# FORMAL OBJECTION TO PLANNING AMENDMENT

## [2025/70/91279/E]

I am writing to object to planning application [2025/70/91279/E] for the proposed installation of multiple industrial air-source heat pumps (ASHPs) and a power substation, and associated mechanical infrastructure, including an external electrical plant area on the Kenmore Drive development site. This proposal raises serious concerns about its timing, siting, and potential impacts on neighbouring residential properties, especially mine.

SECTION THROUGH ASHP ENCLOSURE AND ADJACENT PROPERTY - Scale 1:50

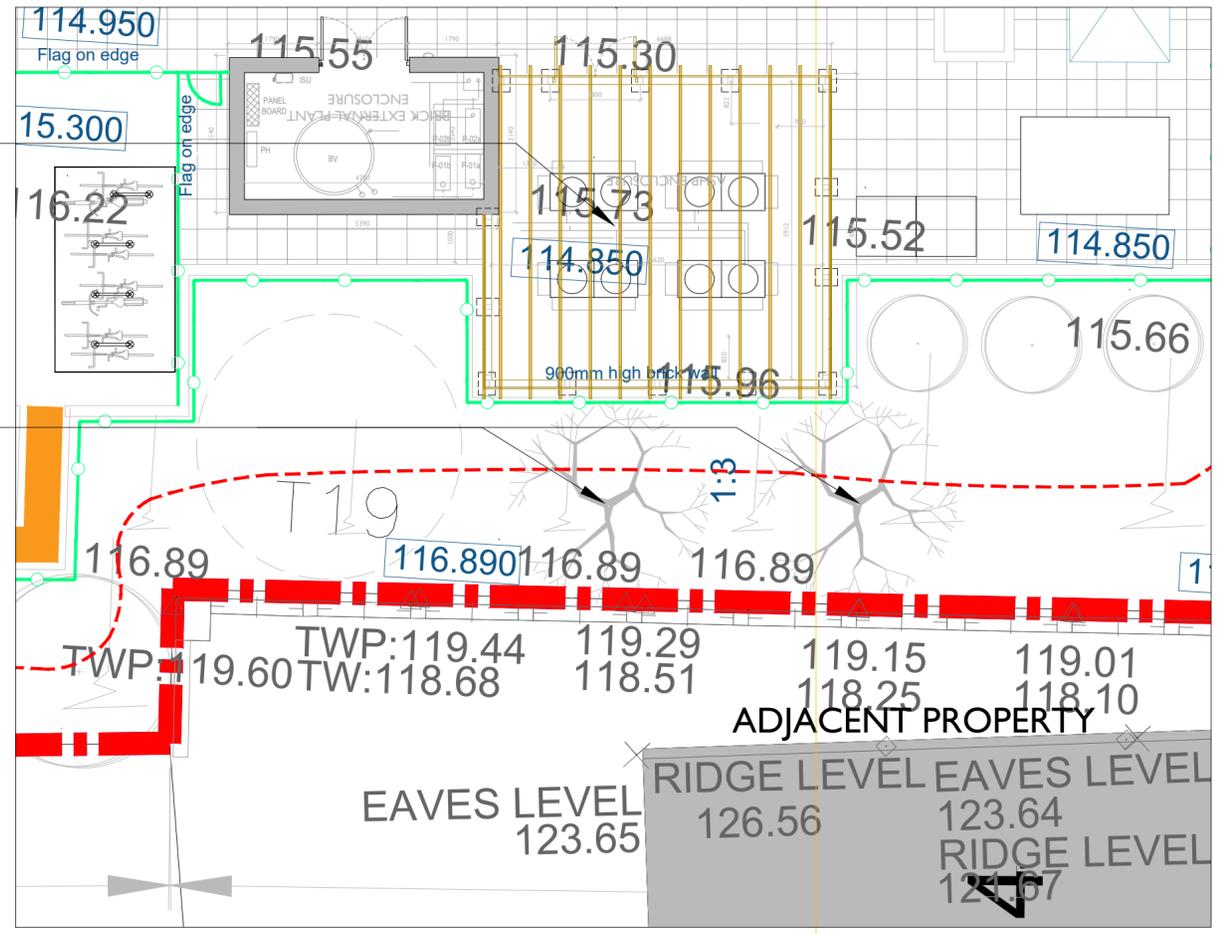
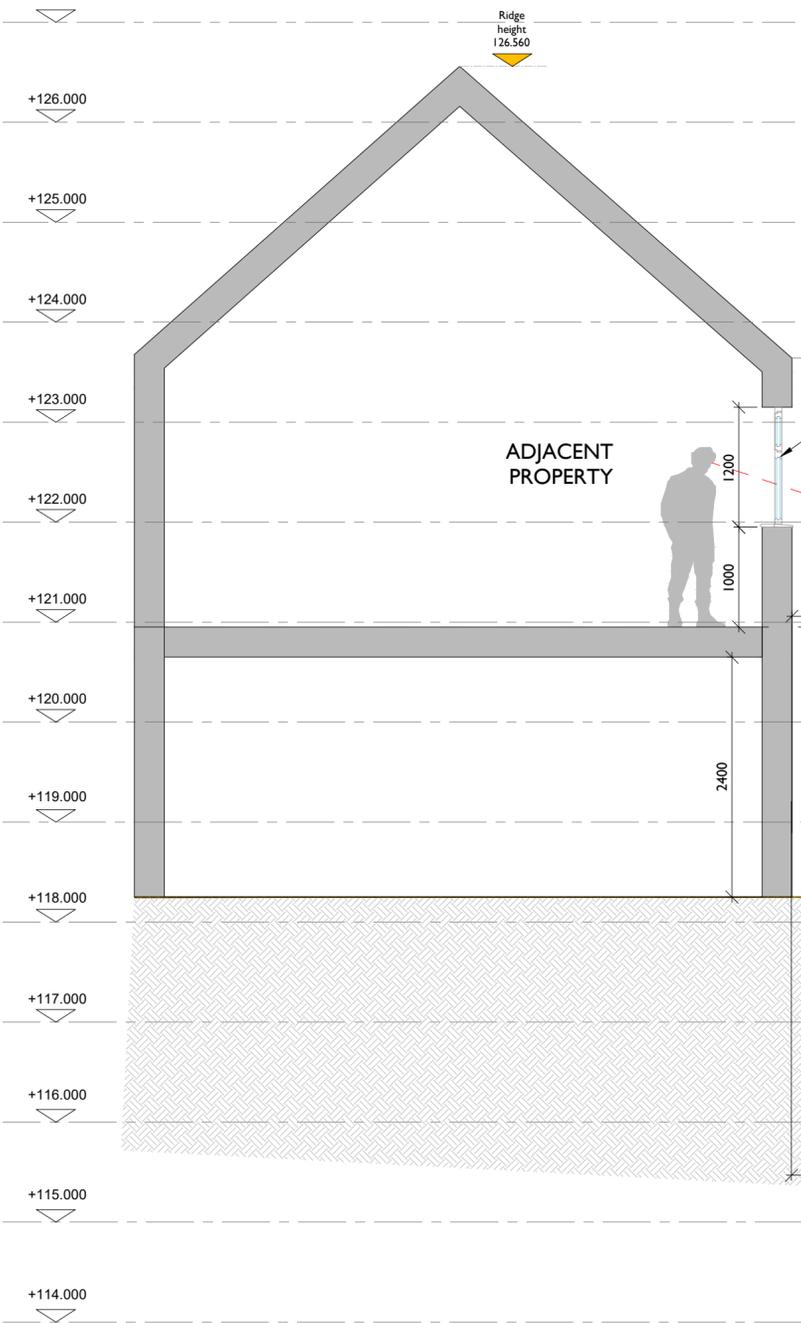
- Model/design mismatch: The acoustic model assumes a high-performance enclosure; the drawings (e.g., 1101392 / 1101394) leave uncertainties about height/roof, materials, linings and maintenance access. If service access requires doors/roof open, attenuation collapses.

Reverberant “slot” geometry between building and boundary: The ASHP compound is proposed within a narrow slot between the new building’s south wing and my boundary, measured at approximately 2.5 m from the pillar fence line to my façade on plan 1101390. Two largely reflective surfaces facing each other (masonry façade and boundary/retaining wall) will produce strong early reflections and a “canyon” effect, increasing the effective sound at my windows and garden. The Nova Rev 003 model does not account for these local reflection gains or for diffraction around the enclosure/wing corner and should be revisited.

- Geometry-driven amplification: The ASHP enclosure and building face form a hard-walled “canyon” facing my property, with a very small stand-off to the boundary ( $\approx 2.5$  m, plan 1101390). This promotes façade reflections and low-frequency build-up, increasing both airborne noise and the likelihood of structure-borne transmission into my pile-founded slab. No ISO 9613-2/CNOSSOS 3-D propagation with reflective façades, nor any BS 6472-1 vibration assessment, has been provided to account for this foreseeable amplification;
- Continuous noise and potential vibration from ASHPs and the substation;
- Ventilation noise/odour from the kitchen;
- Fire/safety concerns from the external plant area (likely inverter/battery elements) and large refuse storage;
- Hygiene risks from commercial-scale bin capacity.

ASHP & EXTERNAL PLANT ENCLOSURE PLAN - Scale 1:50

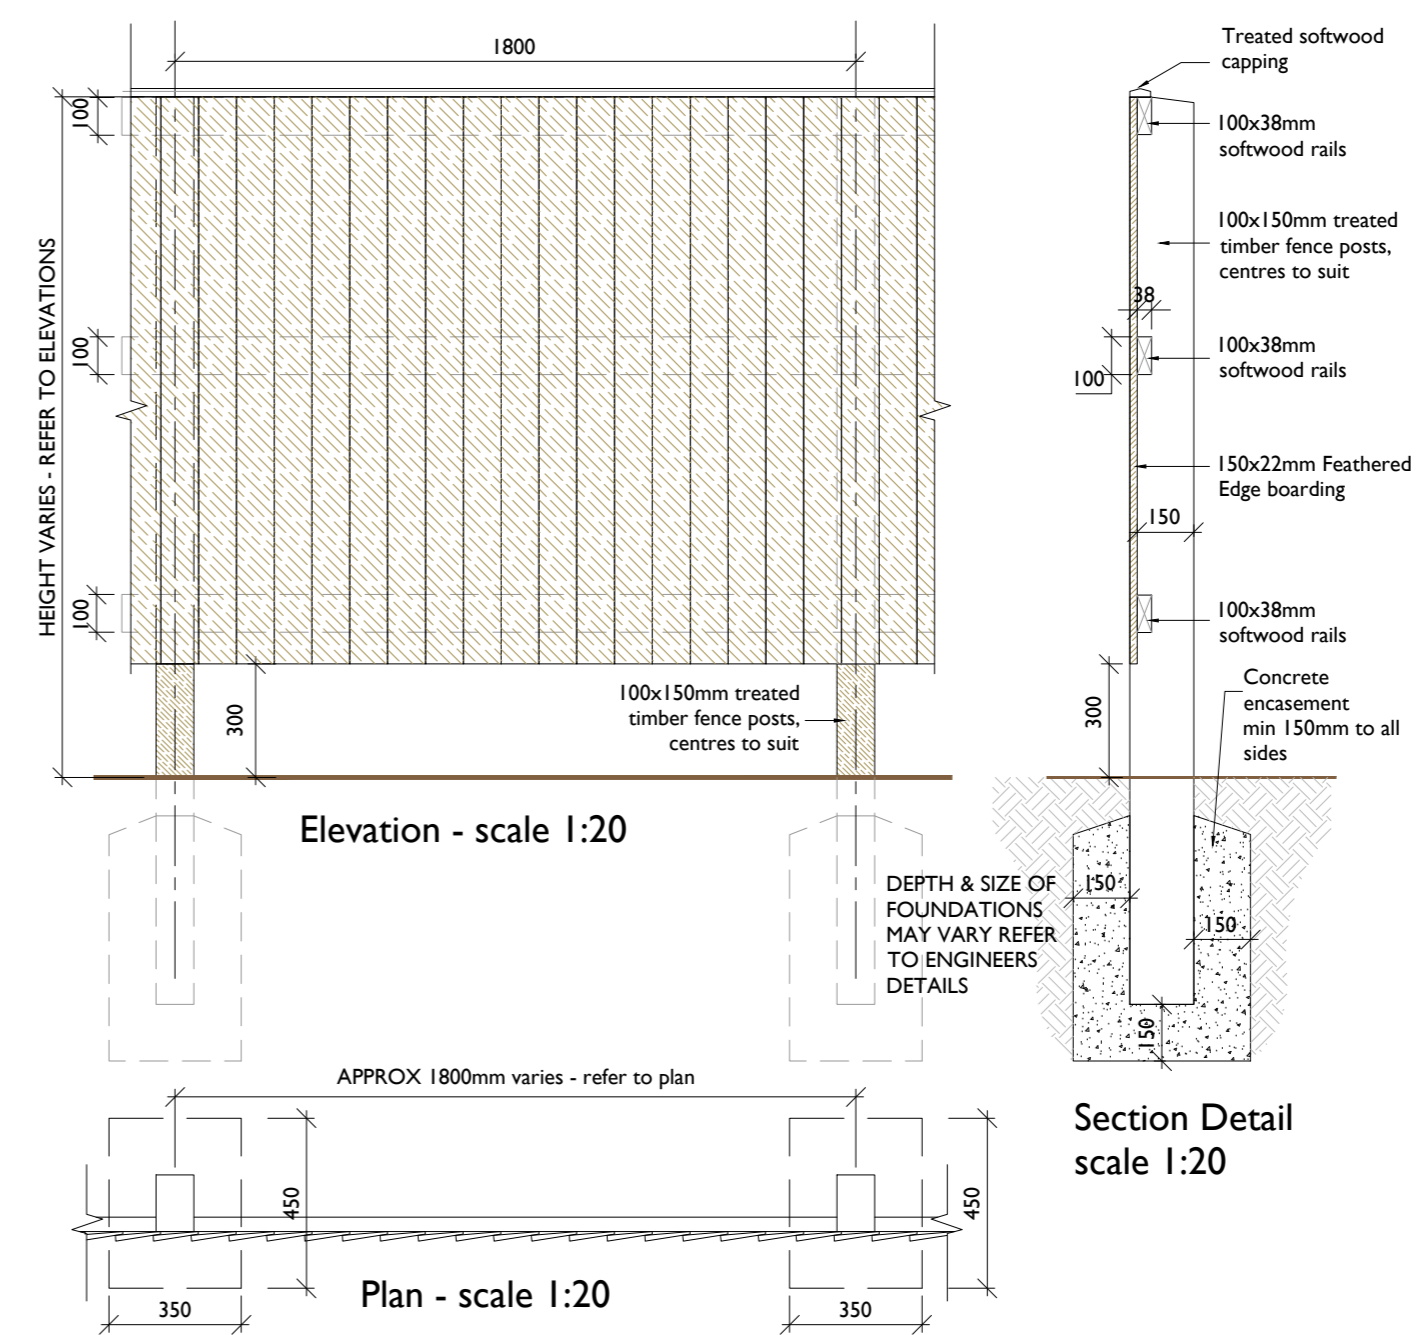
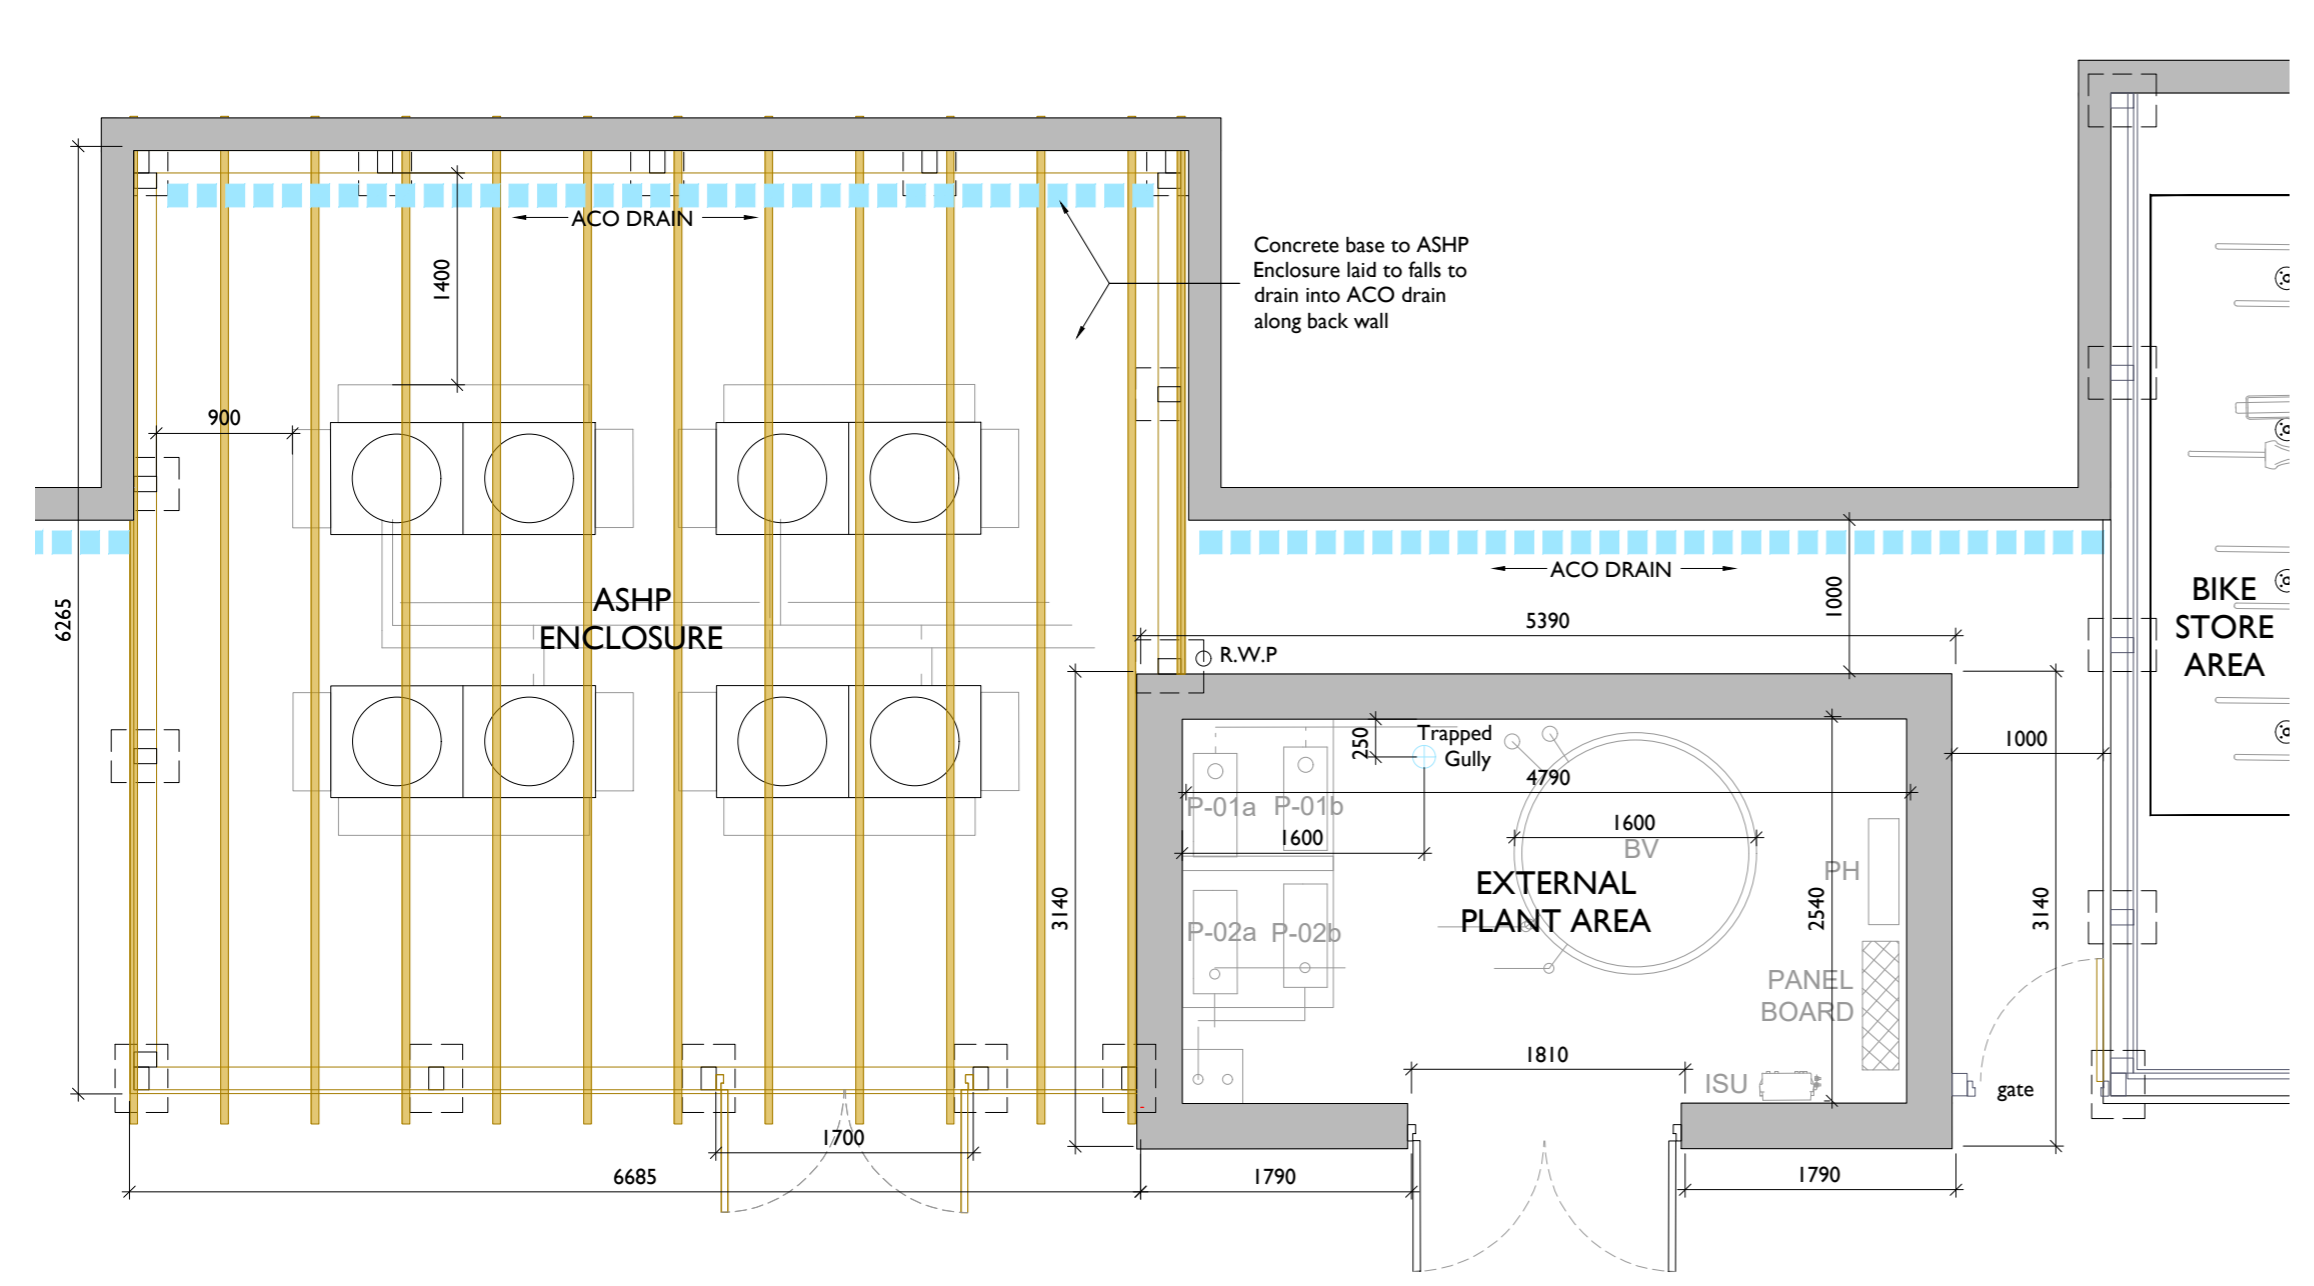
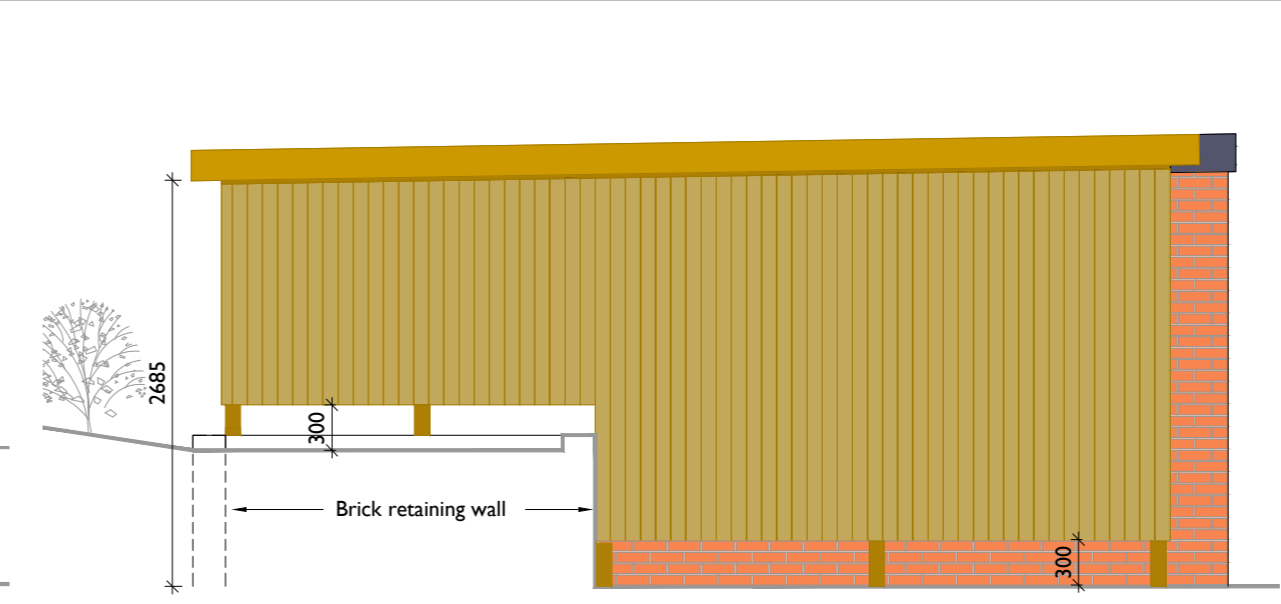
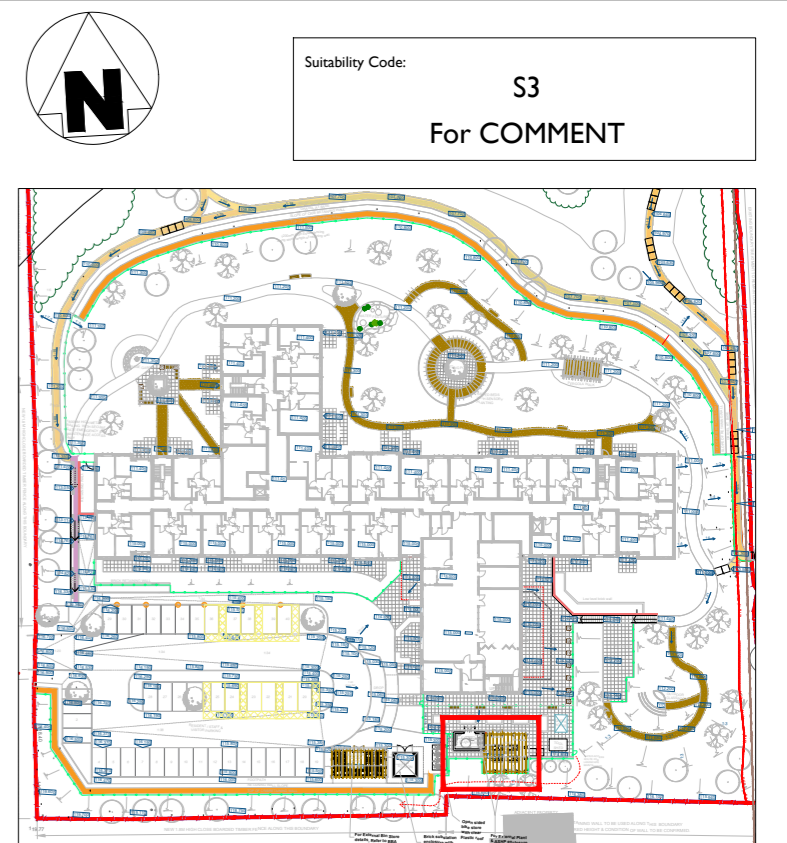
Environmental Health (1094784) indicates acceptance only on the basis that the specific modelled mitigation is delivered and maintained; any variation risks breach. The current drawings (1101390 / 1101392 / 1101394 / 1101393) do not bind the precise enclosure height, internal linings, door/roof construction, plant models or internal clearances on which the acoustic results depend, so compliance is not presently enforceable.

Visual intrusion and overbearing impact (drawings 1101390 / 1101392): The revised Proposed Site & Block Layout (1101390) and Grouped Plans & Elevations (1101392) increase the visual prominence of the plant/service areas, including the ASHP enclosure. The added height and bulk of screens/fencing do not mitigate visual dominance; rather, they create an overbearing presence to my garden and bedroom outlooks, contrary to LP24 (Design) and LP52 (Environmental Quality). Materials/finishes for the enclosure and fencing remain unspecified/ambiguous, preventing proper assessment of their effectiveness and longevity. In visual terms alone, the proposal results in an unacceptable loss of amenity.
